January 20, 2021

Candice Pon
Planning Officer
Planning & Assessment
Department of Planning, Industry and Environment

Re: Building R4B alterations and additions (SSD SSD-8892218)

Axonometric - Proposed Design

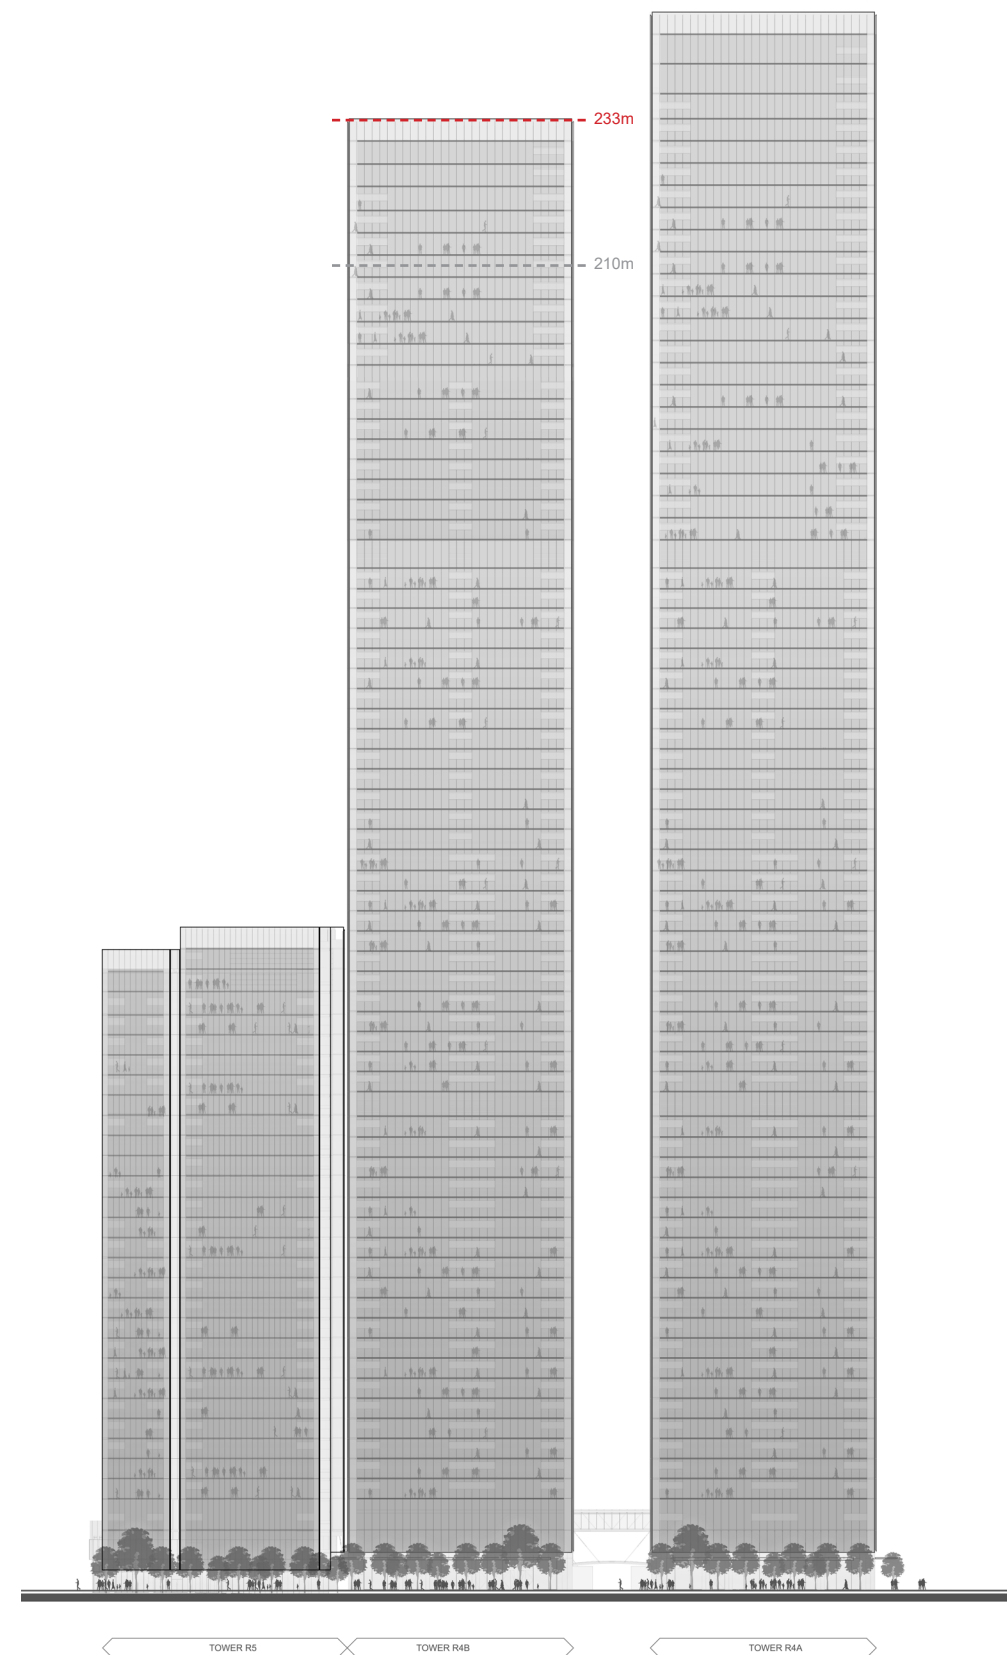
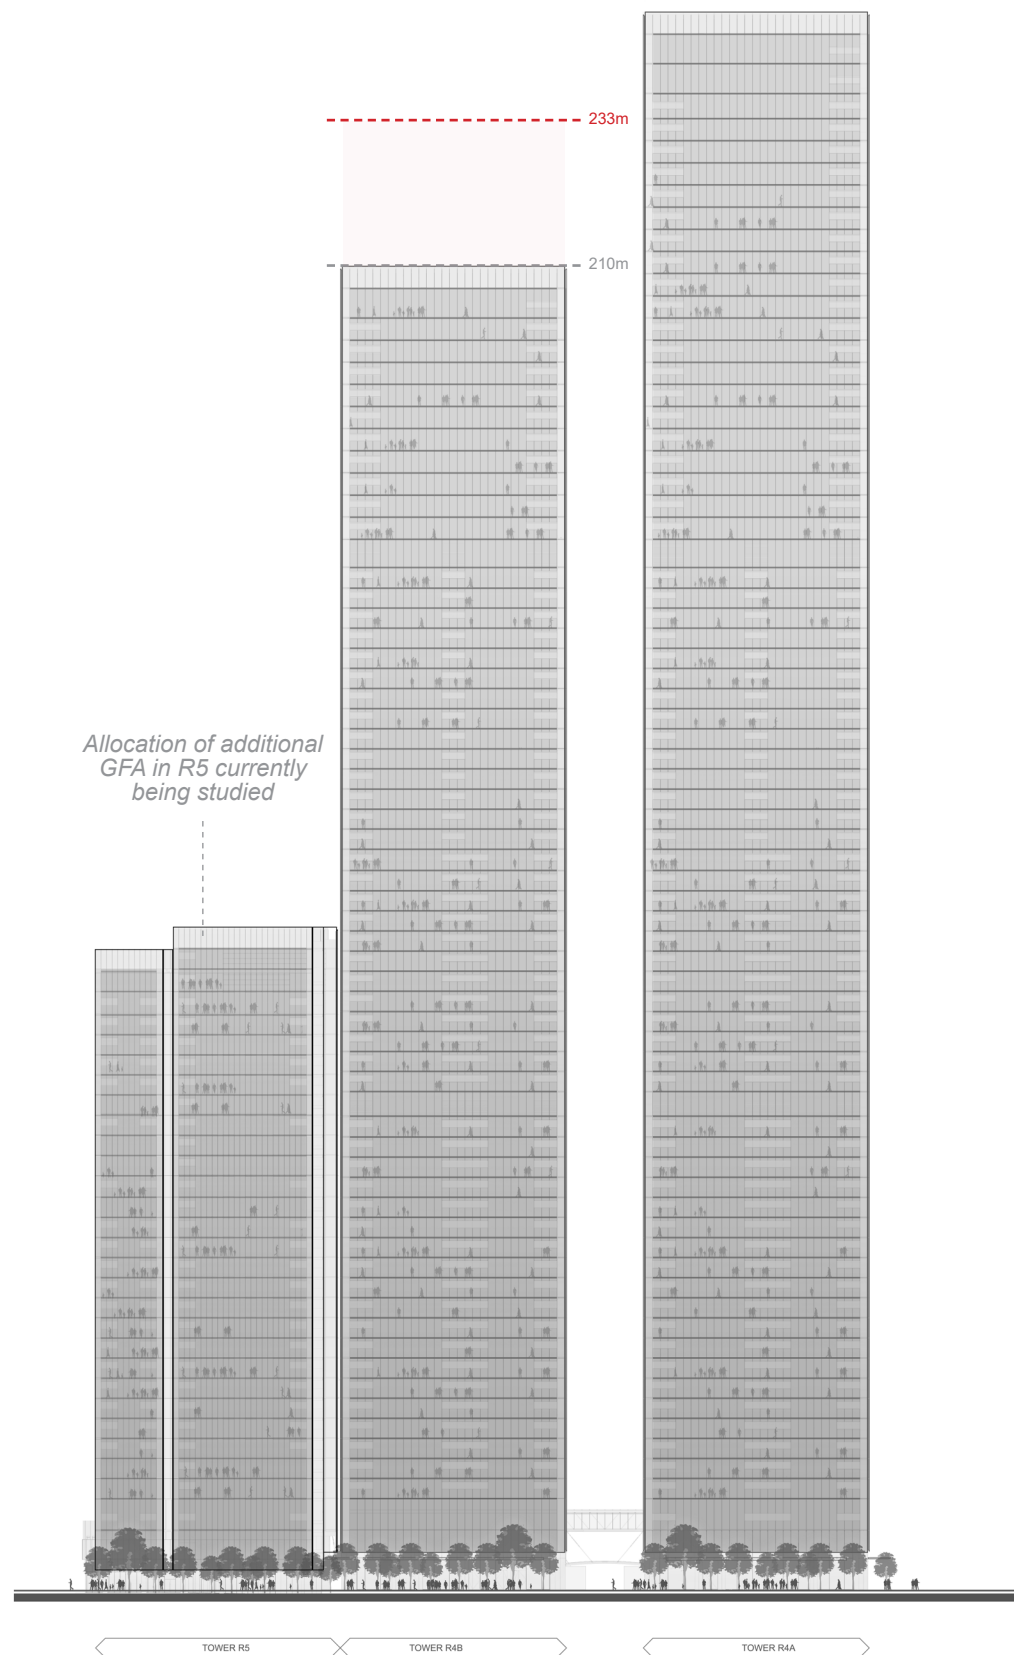
The Museum wishes to raise two potential areas of impact on Sydney Observatory resulting from the proposal to increase the height of R4B from RL 210 to RL 235 (+ 25 m). The potential areas of impact are Sky View Loss and Light Spill.

The 25m increase in height of Building R4B will significantly reduce opportunities for viewing of celestial objects of interest from Sydney Observatory, including:

- The Jewel Box Cluster (open star cluster);
- The Southern Cross; and
- The Pointers (Alpha and Beta Centauri).

Item	Impact	Recommended condition
Sky view loss due to building height increase	Reduced opportunities for viewing of celestial objects of interest from Sydney Observatory	The Museum requests that the proponent is required to consult with MAAS on potential initiatives to mitigate the impact of sky view loss
Increased light spill impact due to building height increase	Negative impact on ability of Sydney Observatory to conduct its core function as a public observatory	The Museum requests that the proponent is required to consult with MAAS on building lighting throughout design and construction phases in order to minimize the impact of light spill to the greatest extent possible
